CITY OF ALBUQUERQUE

March 17, 2025

Re: Bluewater Galleria
Traffic Impact Study(K10D023L)
Engineer's Stamp 3-6-25
Via email: tsimmons@civiltransformations.com and ABQ-PLAN

The subject Traffic Impact Study (Study) draft received on March 6, 2025, has been reviewed by the City of Albuquerque Planning Development Transportation Section and provides the following comments.

SP-1

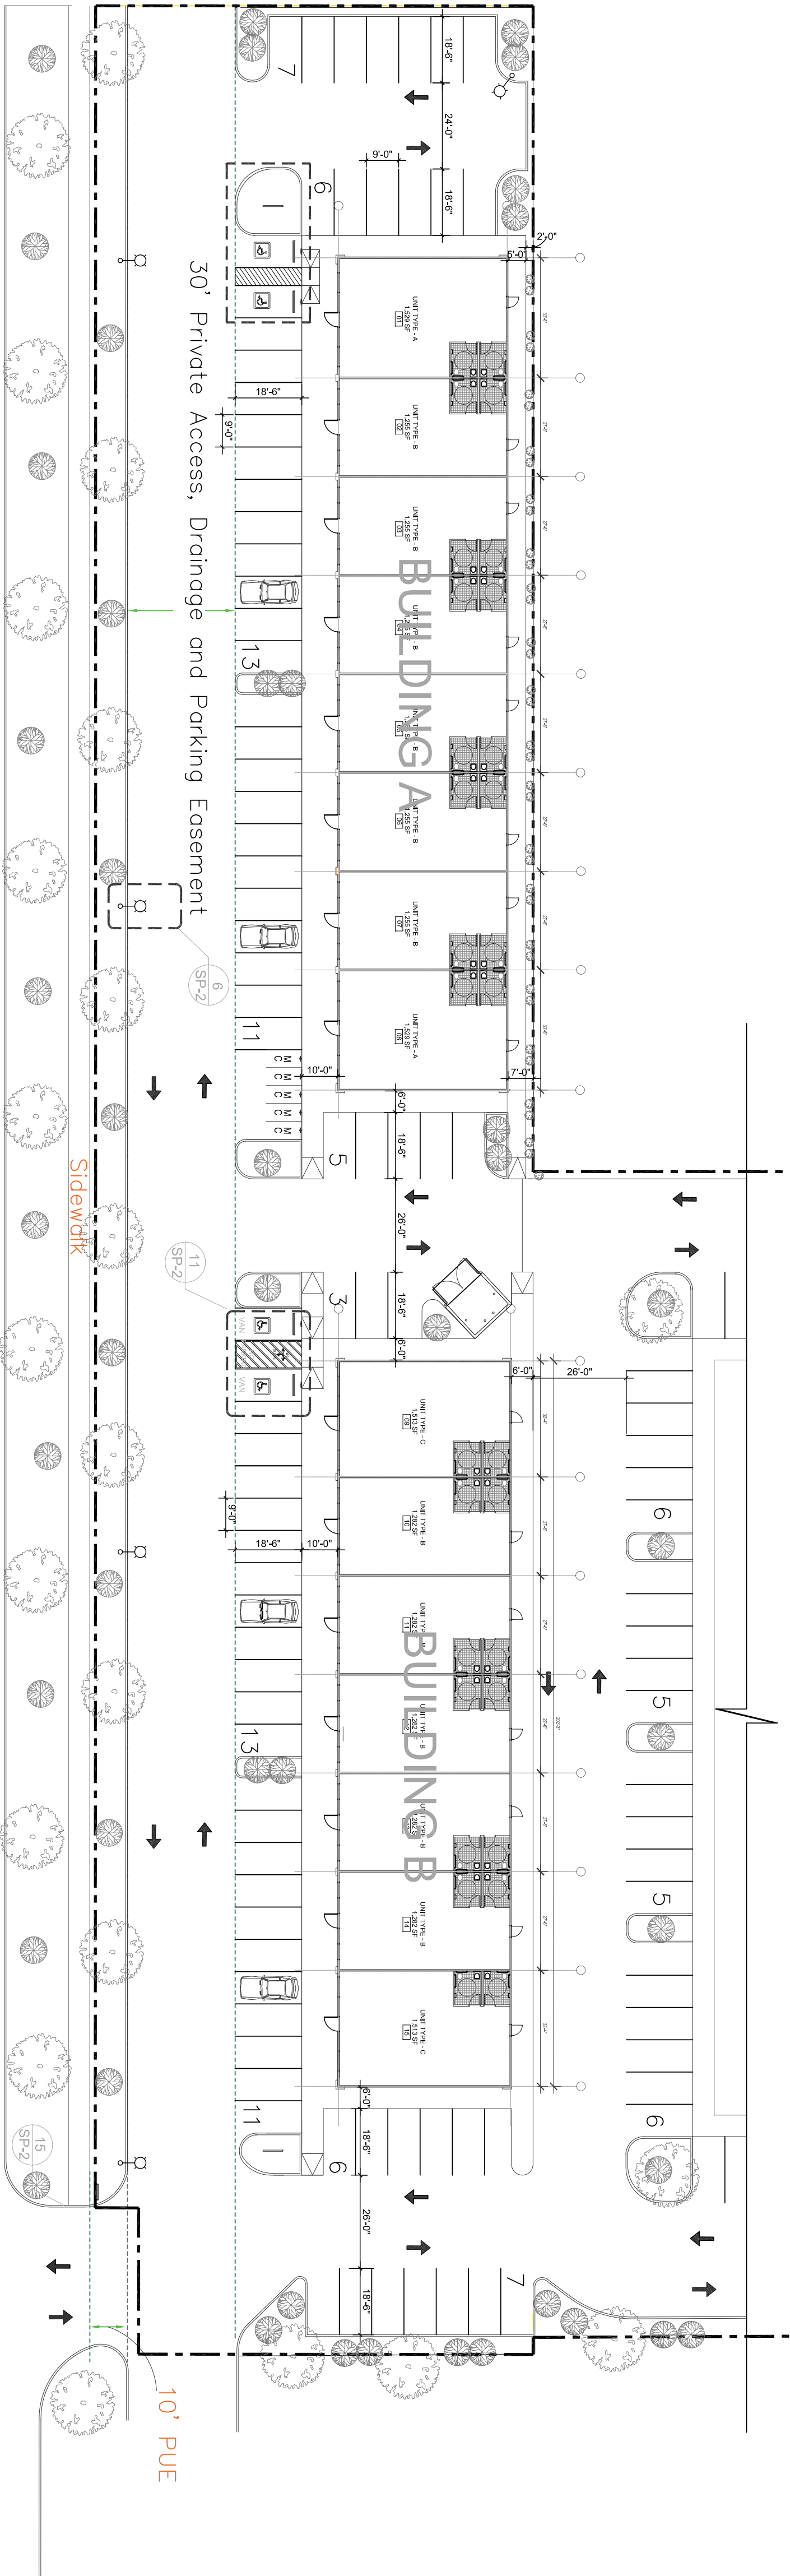
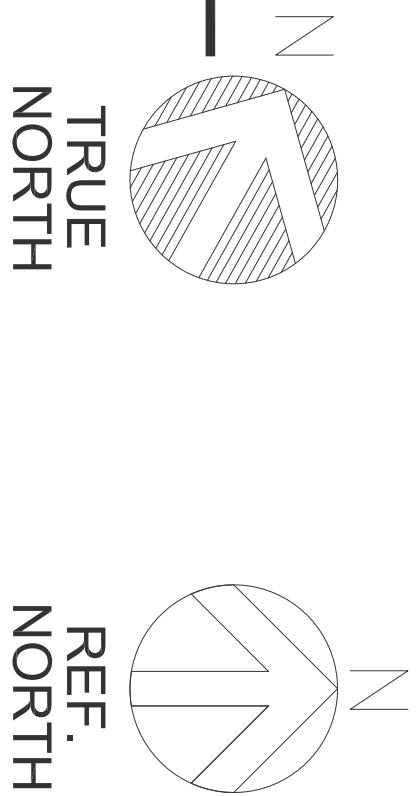
1. The Site Plan, Figure 6 shows 3 driveways, yet only two are labeled and the third is sporadically discussed, Assign trips to the secondary gated access on Silver Creek Rd and include the access throughout the Study and label the driveway on the Site Plan.
2. Figures 2,3,4,7 have white and blue labels with numbers. Explain the purpose of the different colors and the numbers to the reader.
3. In the LOS summary tables, provide a separate column each for through and right movement.
4. To assist in enforcing the right-in/right-out at the Unser Blvd access, developer to construct approximately 100 ft of curb/lane delineator posts along the median and place a turn arrow sign (W1-6R-36) in the median across from the access.
